DEVELOPMENT REVIEW BOARD
SUPPLEMENTAL SUBMITTAL

PROJECT NO. PR-2021-005459
Application No. SD-2021-00163 SI-2021-01248

**RE: PR-2021-005459 RESPONSE TO DRB COMMENTS
LOT 1A BLOCK 2 & LOT 2-A-1 BLOCK 2 SUNPORT PARK
2900 TRANSPORT ST NE**

The following items in this letter below provide the various adverse comments received from the Development Review Board plus responses for those comments as shown in bold for the approval request of Site Plan and Preliminary Plat.

| | REVIEWED | A-104.1 |

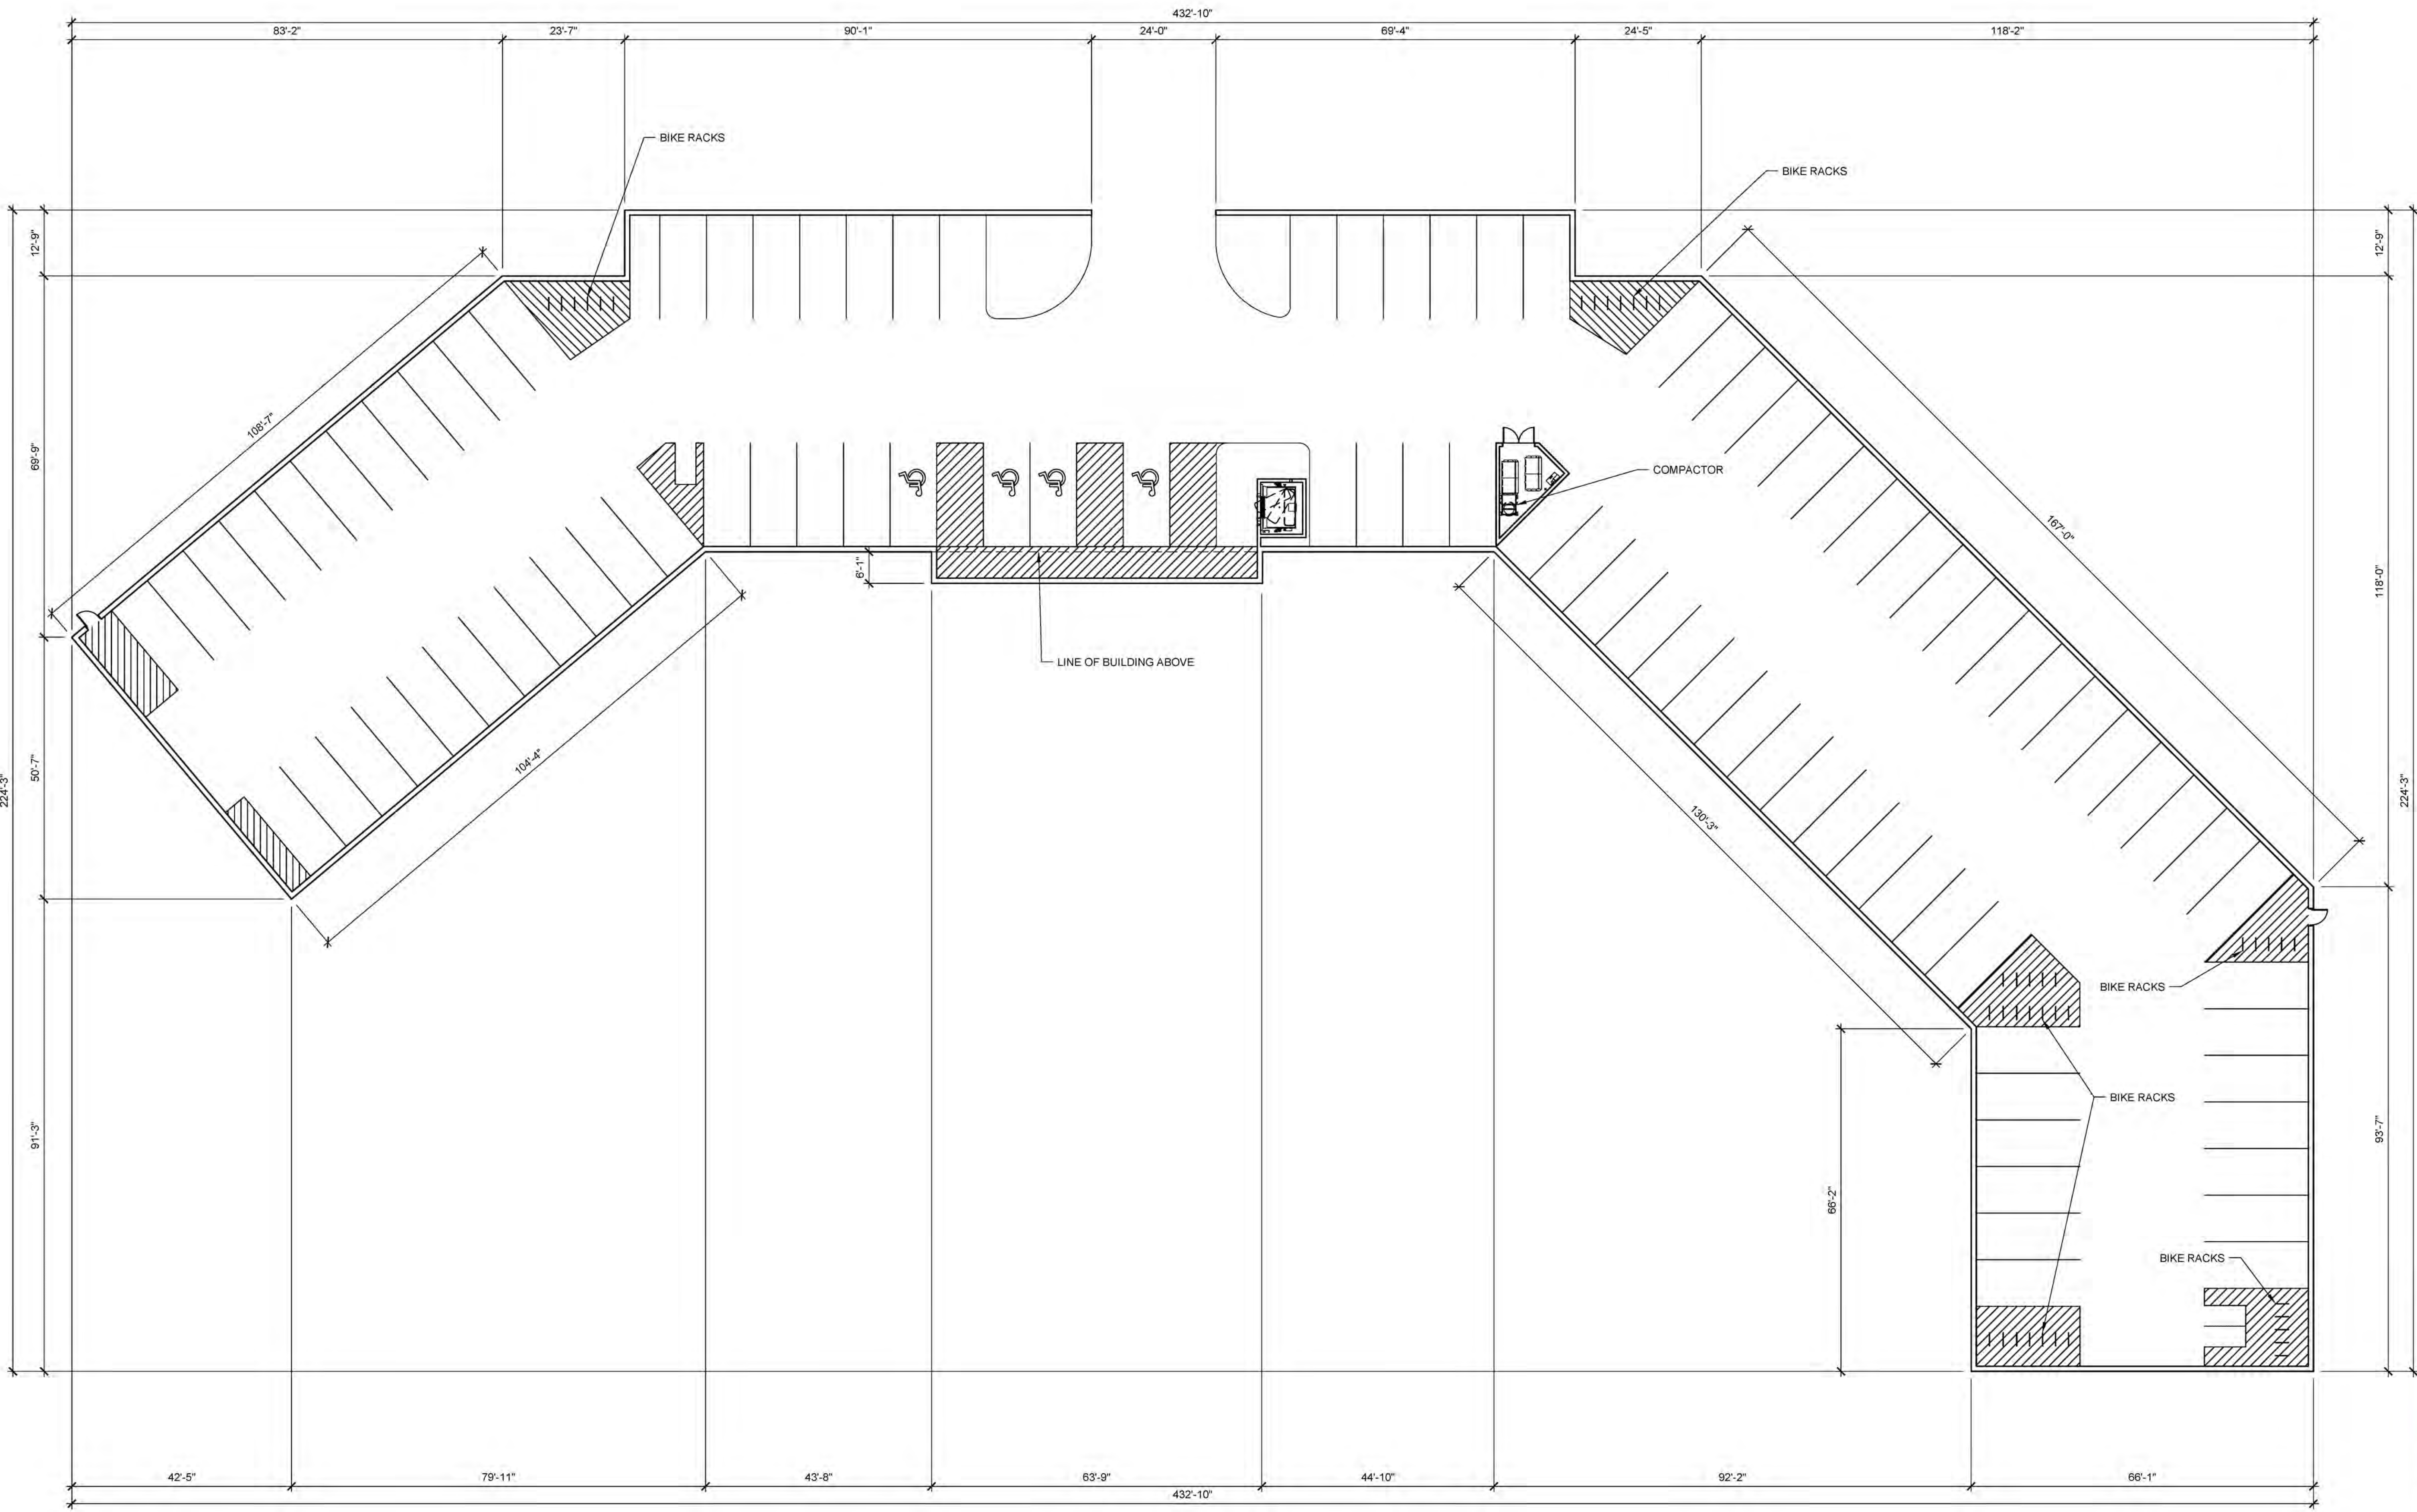
9. Along the north side, the van accessible aisles are not adjacent to sidewalk for ADA access (far north side near the north access way).

RESPONSE: The ADA spaces in question are within the underground parking structure. After some correspondence with Jeanne Wolfenbarger on this, the ADA parking in this area has been adjusted to have a 4' wide adjacent accessible route to the elevators in this parking structure. See Floor Plan sheet A-104.1, the footprint of the underground parking floor will actually have a "bump-out" for this accessible route that the first floor of the building does not have, as depicted on the site plan sheet.
